Rezoning Transportation Analysis

Petition Number: #2022-051

Date	Description
08-24-2022	First Review (KP)
09-22-2022	Second Review (KP)
10-26-2022	Third Review (DR)

CONCEPT PLAN - SF ATTACHED

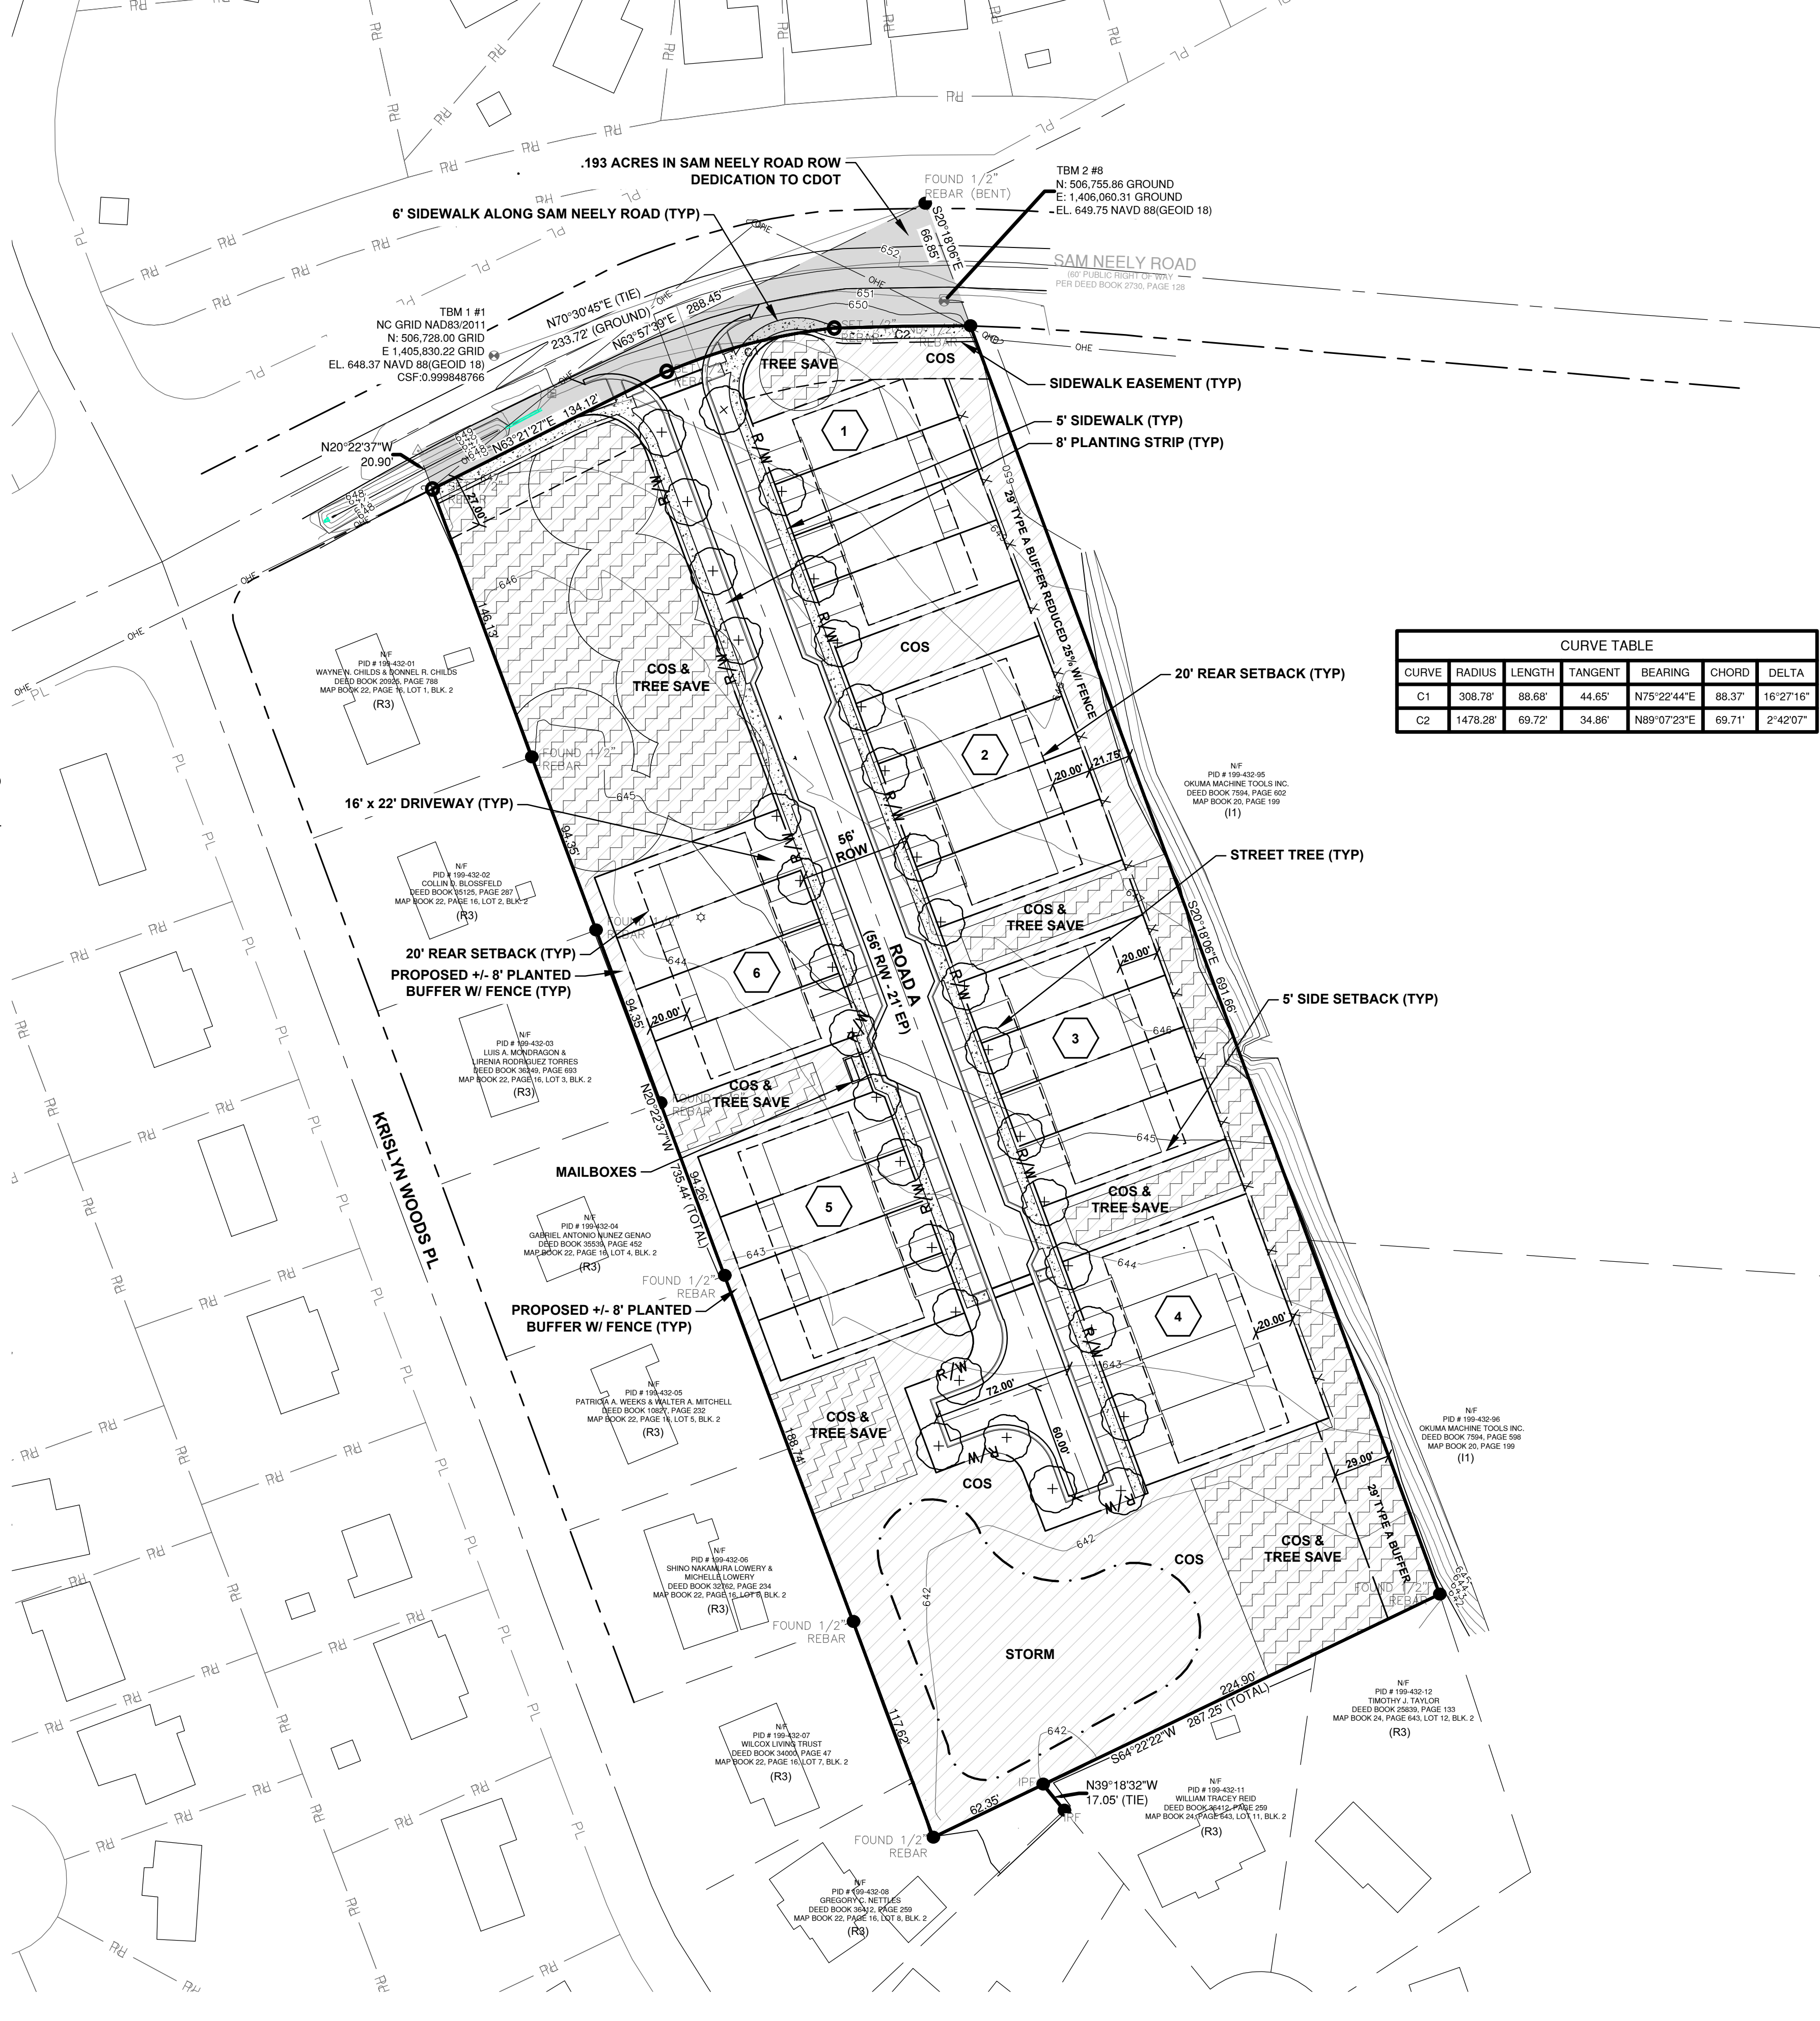
- ~~1. Revise the site plan and conditional notes by committing to construct curb and gutter, along the site's frontage of Sam Neely Road, measured 19 feet from the existing centerline to back of curb.~~

~~Label and dimension the back of curb from the existing centerline of Sam Neely Road.~~

- ~~3. Revise site plan and conditional note(s) to commit to dedicate 43 feet of right-of-way along the site's frontage of Sam Neely Road.~~

~~The site plan shall label and dimension the right-of-way from the road centerline.~~

- ~~4. Revise site plan and conditional note(s) to commit to construct an 8-foot planting strip, and 12-foot shared-use path along the site's frontage of Sam Neely Road. The site plan shall label and dimension both items from the back of curb and gutter.~~

- ~~5. Revise the site plan and conditional notes to commit to construct proposed Public Road A in accordance with CLDSM U-02, local residential medium street.~~

- ~~6. Revise the site plan by removing the proposed crosswalk markings, across Public Street A, and extending the sidewalk around the hammerhead.~~

12300 SAM NEELY RD
CHARLOTTE, NC 28278
REZONING PETITION # 2022-051
CONCEPT PLAN - SF ATTACHED

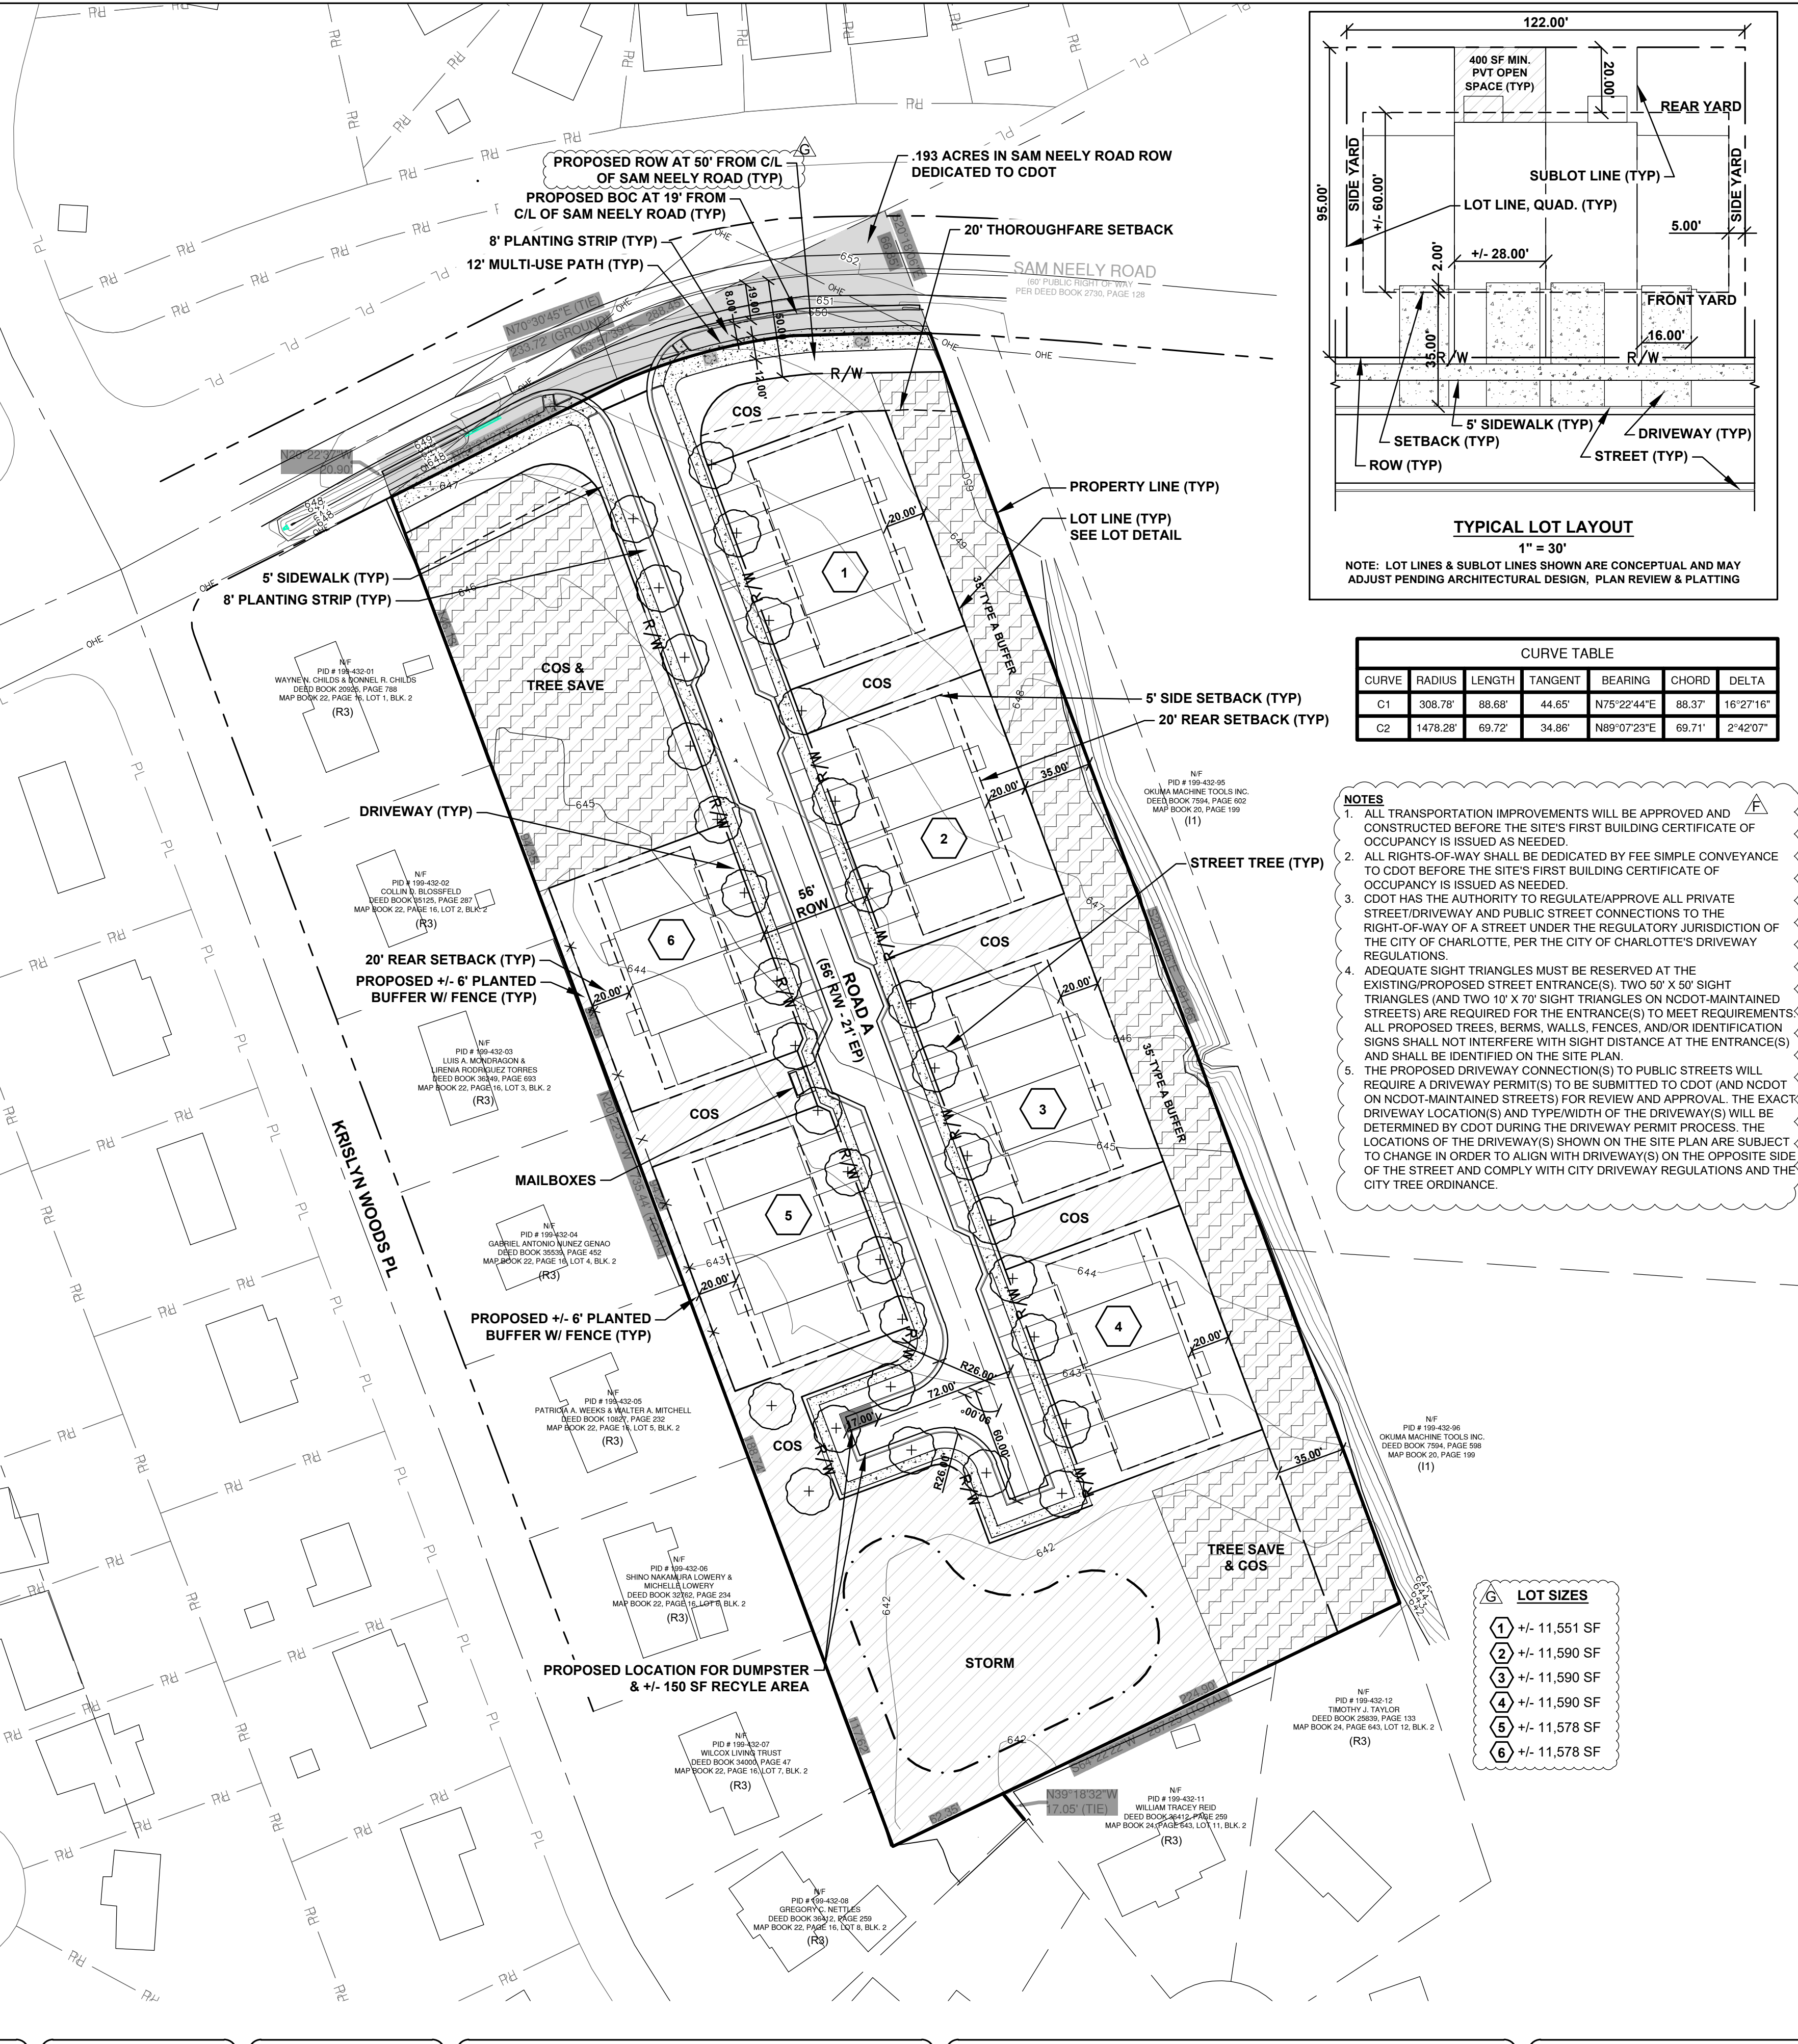
8. ~~A site plan note(s) specifying dedication and fee simple conveyance of all rights-of-way to CDOT before the site's first building certificate of occupancy is issued as needed. CDOT requests rights-of-way set at 2' behind back of sidewalk where feasible.~~

9. ~~Add conditional note: All public roadway improvements will be subject to the standards and criteria of CDOT and will be subject to CDOT approval during permitting.~~

10. ~~A site plan note specifying that all transportation improvements will be approved and constructed before the site's first building certificate of occupancy is issued as needed. The petitioner may phase transportation improvements if said improvements and phasing are explicitly described in site plan notes.~~
